**Development Facilitation Team (DFT) – Review Comments**

**DRB Project No: PR-2020-003484 Date: 06/28/2023 Agenda Item: #9 Zone Atlas Page: E-10**

**Application For: SD-2023-00048 – PRELIMINARY PLAT (DHO)**

DRB Project Number: 2020-003484 Hearing Date: **06-28-2023**  
 Project: Mojave Ridge Subdivision Agenda Item No: **9**

PRELIMINARY PLAT FOR  
**MOJAVE RIDGE SUBDIVISION**  
 (A REPLAT OF LOTS 2 & 3, BLOCK 12,  
 UNIT 3, VOLCANO CLIFFS SUBDIVISION)  
 WITHIN  
 SECTION 27,  
 TOWNSHIP 11 NORTH, RANGE 2 EAST, N.M.P.M.  
 CITY OF ALBUQUERQUE  
 BERNALILLO COUNTY, NEW MEXICO  
 JANUARY, 2023

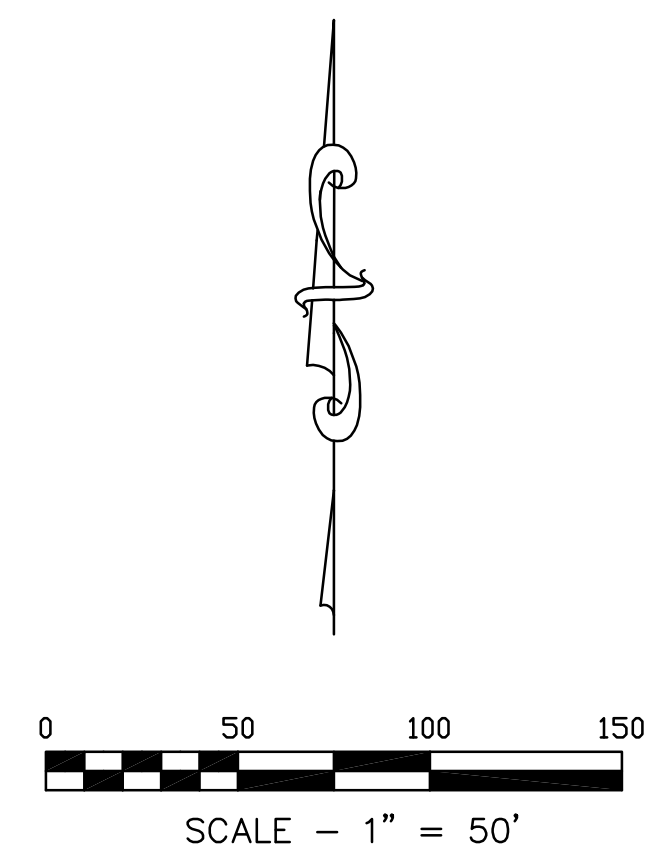
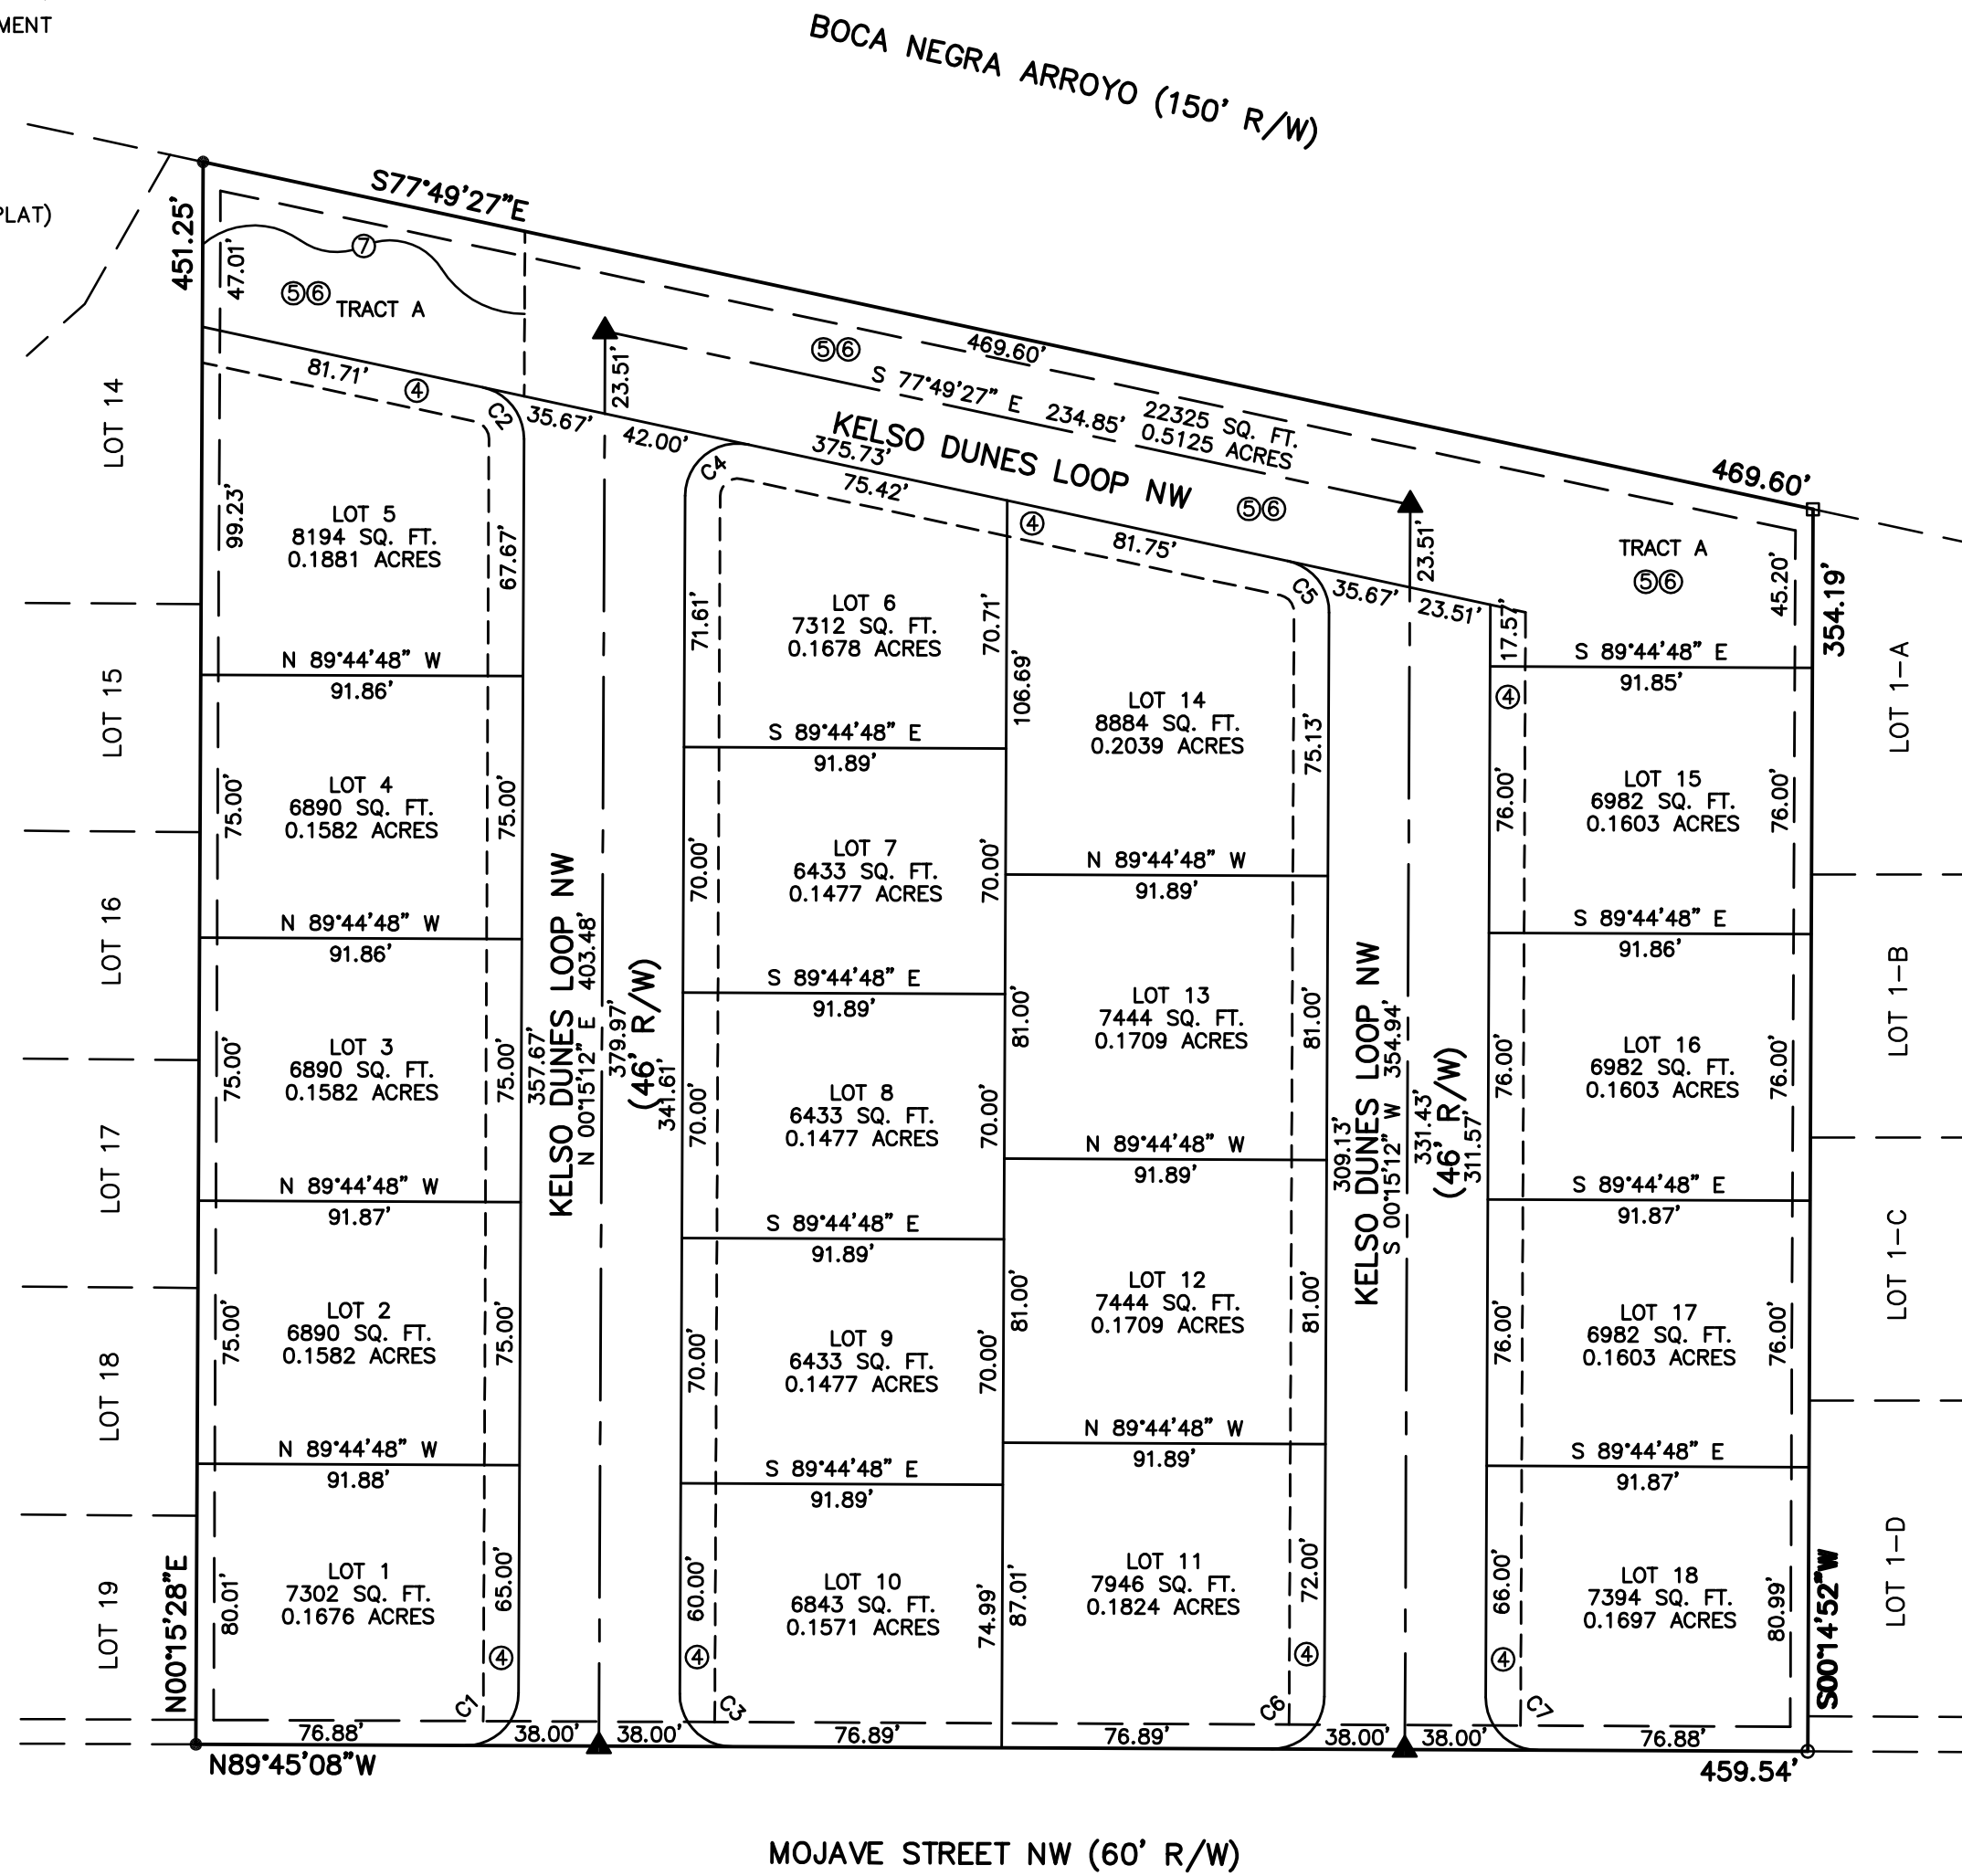
**Updated 6.23.23** Change the maintenance note of Tract A (pond) to be the Homeowner's Association, not just 'owner'; city maintenance is not provided for Tract A. The landscape buffer in the northwest corner of the subdivision should be in a separate tract with a note as shown on the next page.

- b. A post-construction meeting shall be held with MPOS and City representatives to verify the buffer zone, sensitive land feature, or MPOS has been adequately protected during construction.
  - c. Any damaged areas noted shall be restored per contractor expense.
- **Updated 6.26.23** 5-2 (J)(2)(a) Lot 5 is abutting the Boca Negra arroyo. Add a note to the plat indicating that the 45 feet buffer abutting the Petroglyph National Monument must have plant approval and location per the Open Space Superintendent.
